PROFILE & X-SECTIONS
PONDING AREAS
2600 MURIEL N.E.

GRADING & DRAINAGE
PLAN

SANTA ANNA PLAZA

RE: 2601 Juan Tabo N.E. Revised Drainage Plan

DRAINAGE PLAN

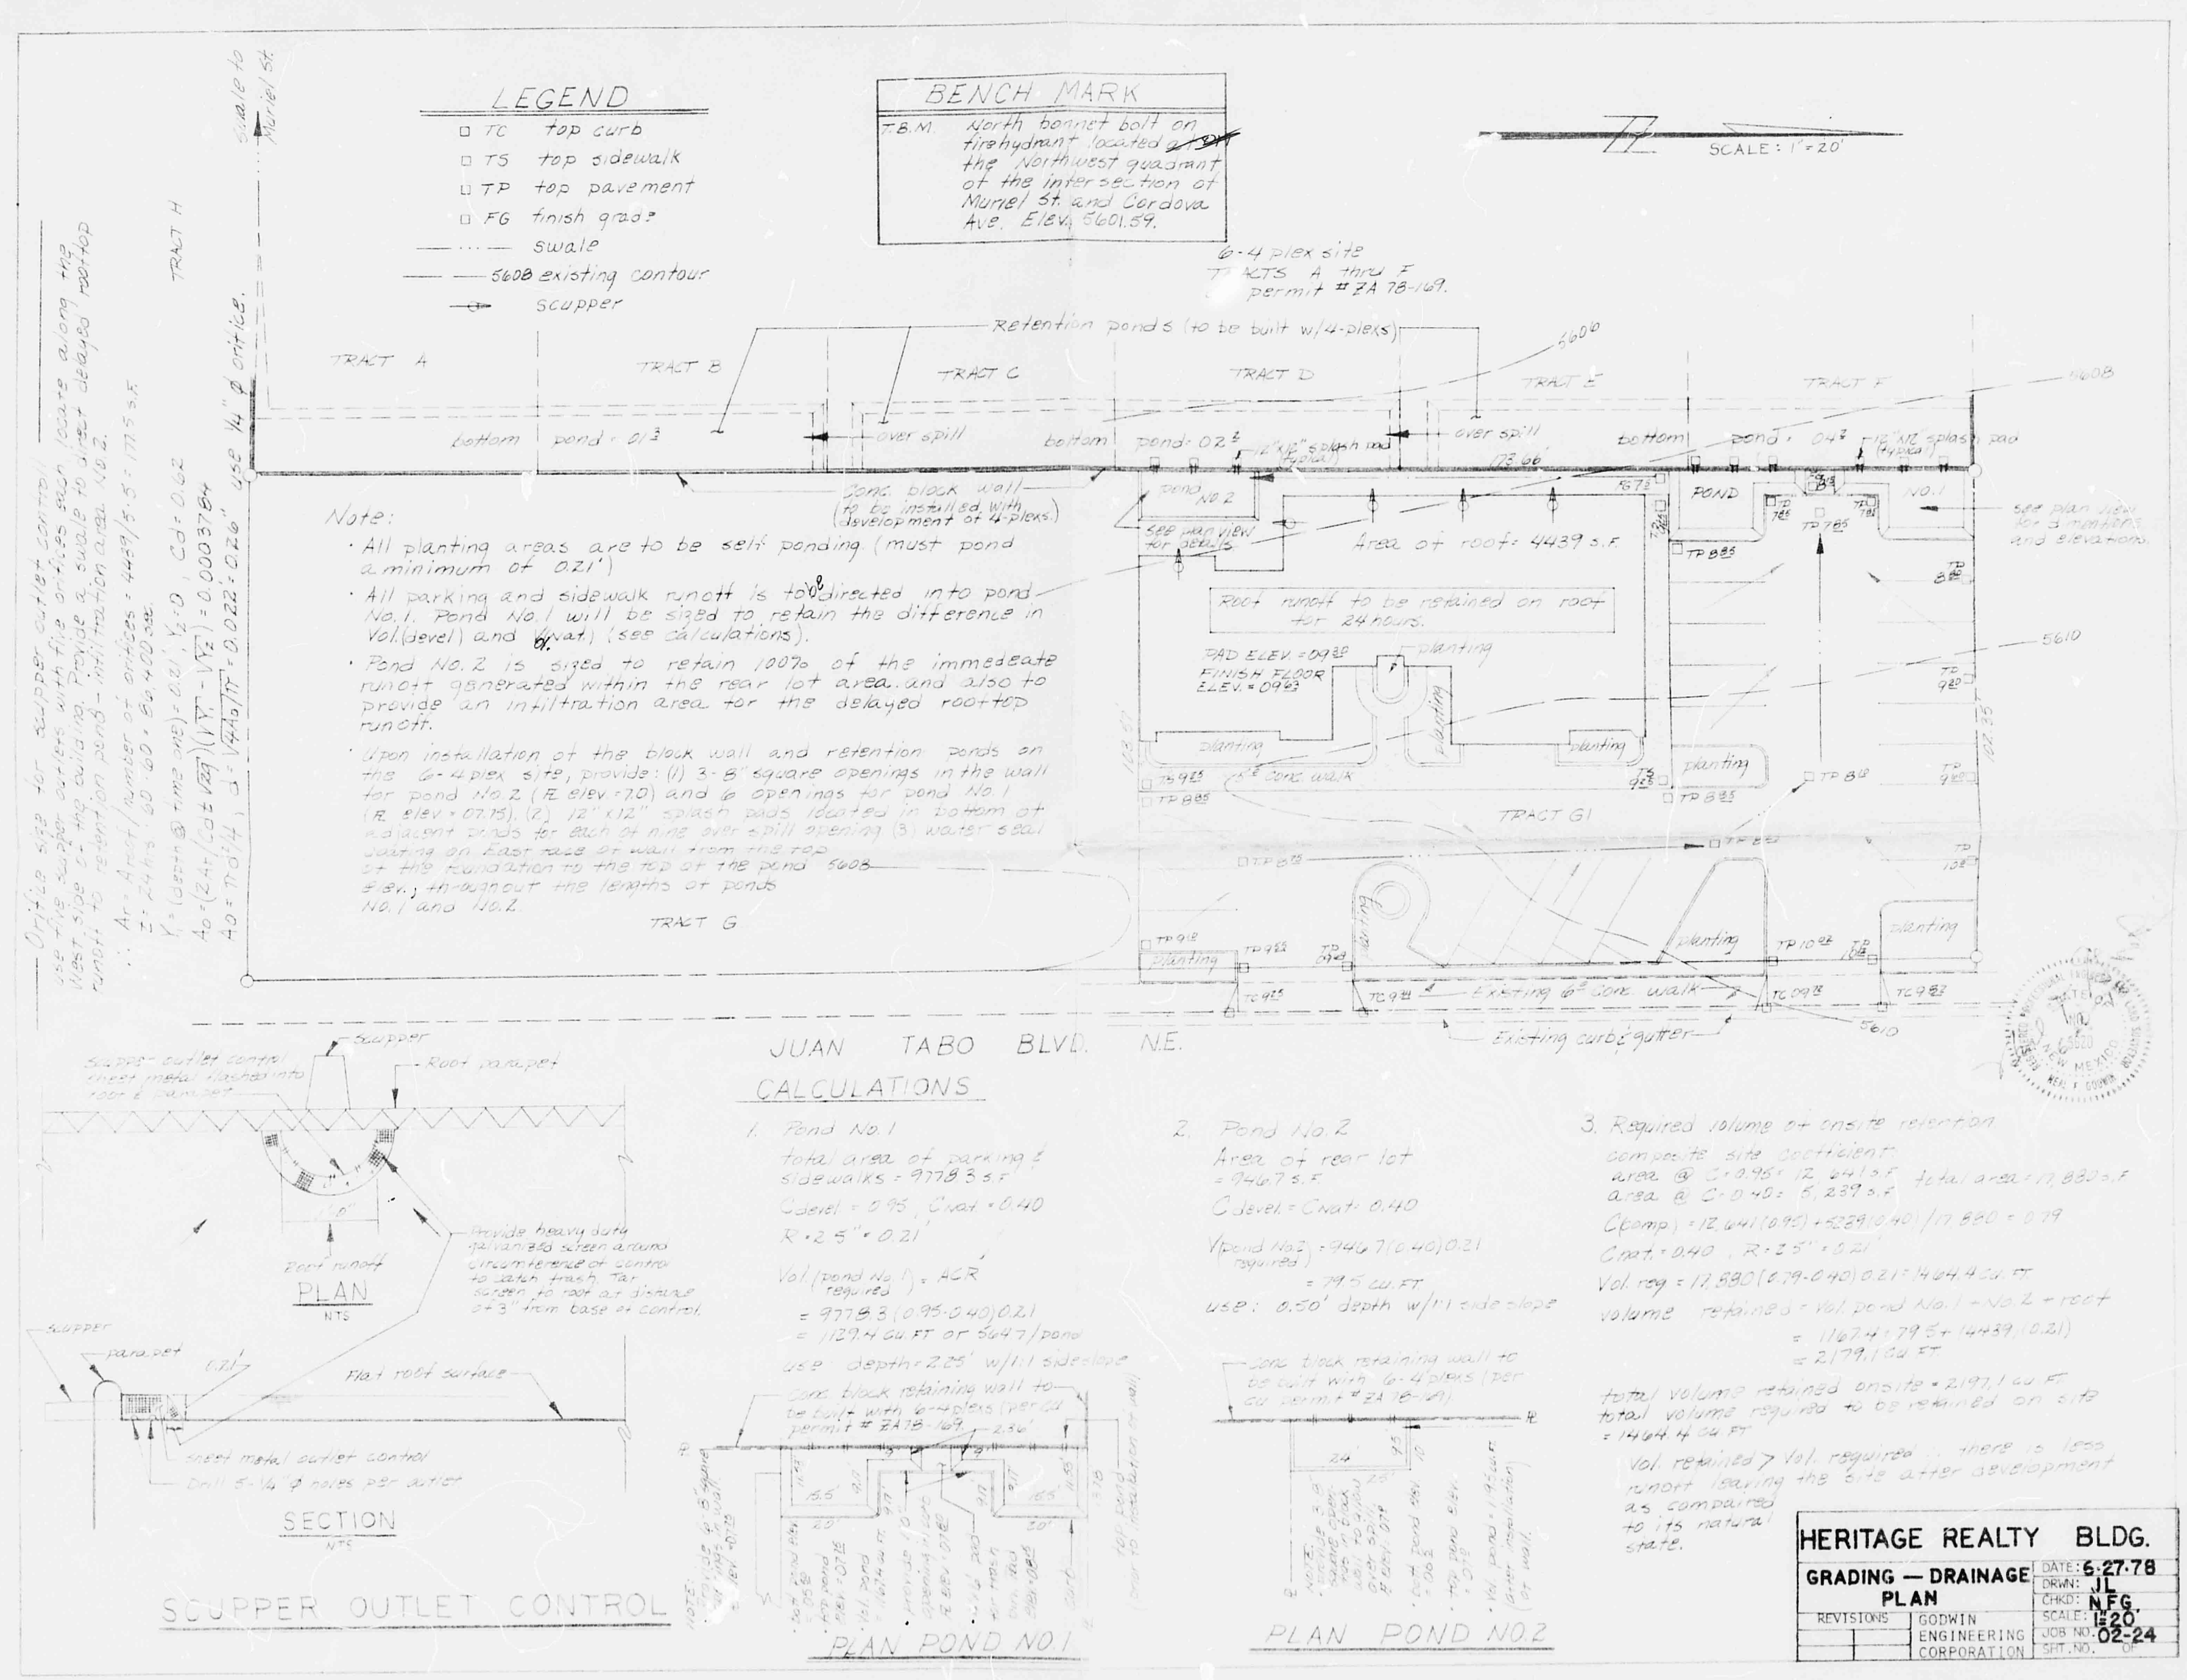
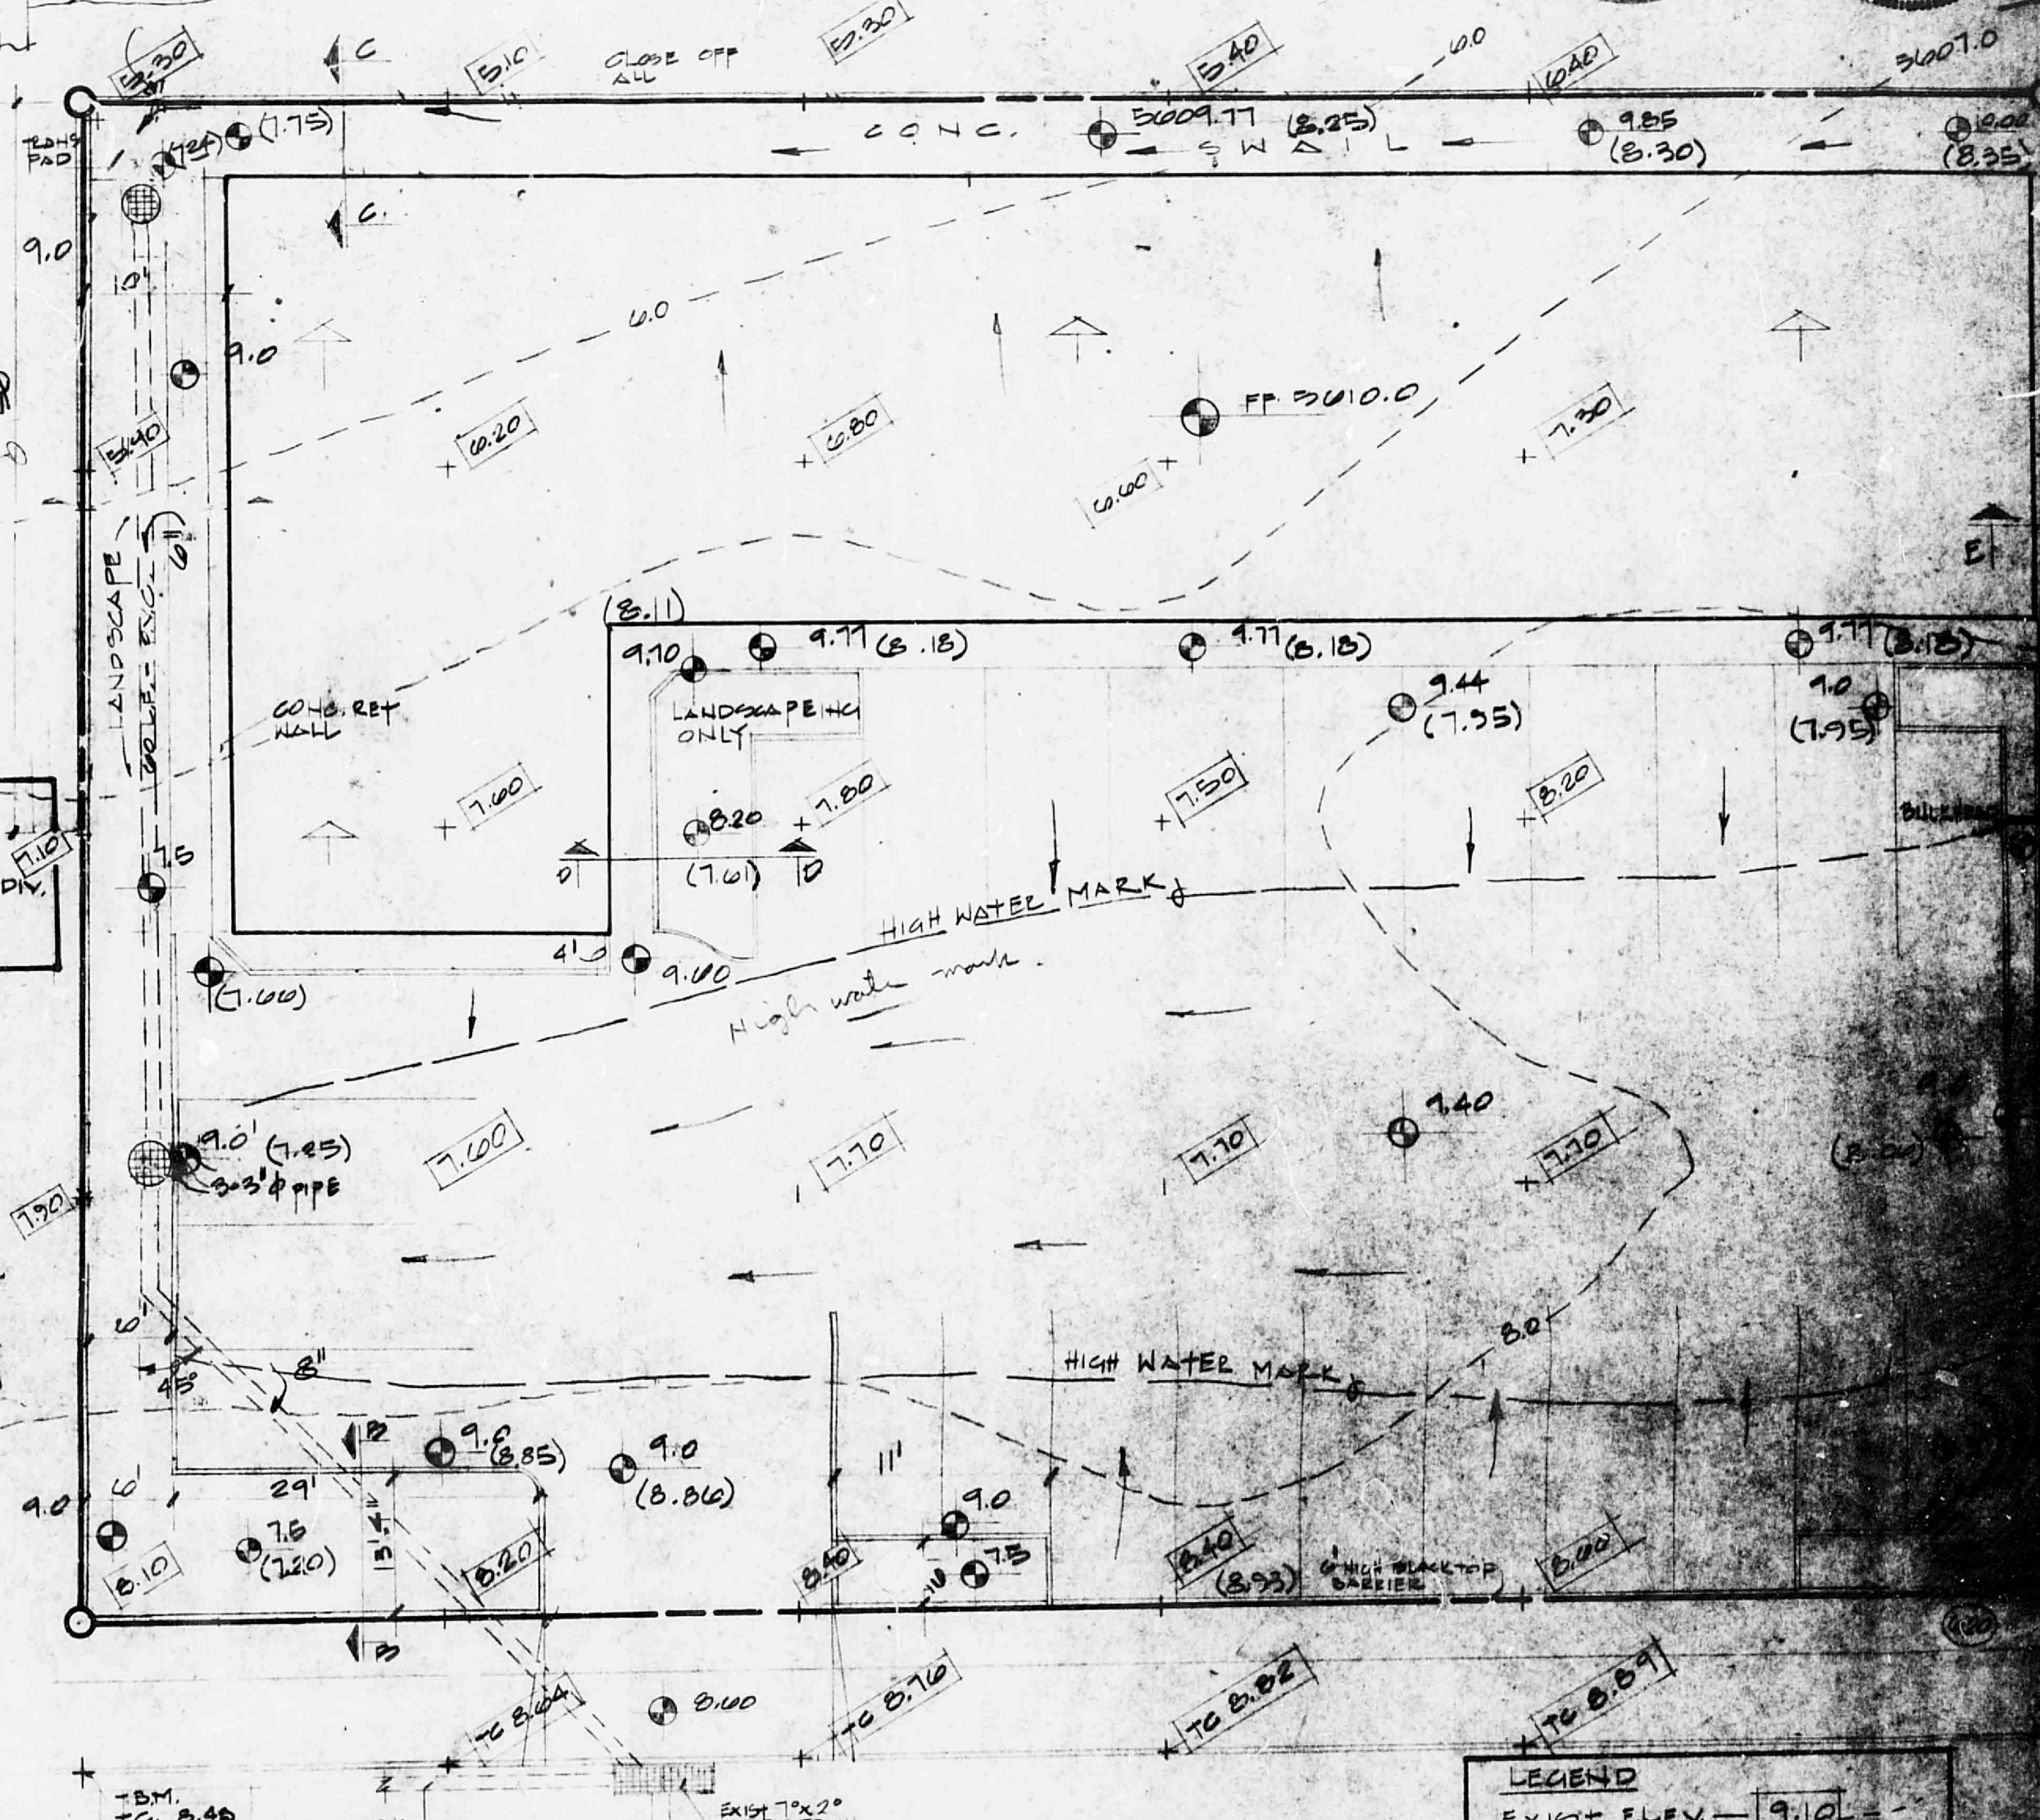
- a. ponding provided within pond #1^{#2} according to your computations does not satisfy the required ponding.
- b. Show what drainage area is draining to pond No. 2 unable to determine the 117 cubic feet that you are taking account for

- c. Provide calculations for verification of 3" ϕ discharge pipe from pond No. 1 as opposed to any other diameter pipe. Also provide computations for pipe outlet at the SW corner of lot.

- d. Indication of all existing structures on or adjacent (15' minimum) to the site, such as the ponding area to the west and the buildings to the North and South. (true distances)

- e. The scheme shown to discharge the 798 cubic feet of runoff from the roof gives us concern. Address the possibility of the 3" ϕ discharge pipes not functioning correctly because of the elevation above the valley gutter and thus causing flooding to take place within the building.

- f. You indicate that there will be 14" of water retention against the bulkhead before the overflow weir will begin to function. Mr Goodwin has already indicated his

concerns on the cracks all along the south side retaining wall. Mr. Fred Aguirre has also made mention that no ponding is allowed within 15 feet of any structure. There is the potential problem that the amount of runoff being retained could have an effect on the structures (retaining wall and also city sidewalk and curb and gutter)
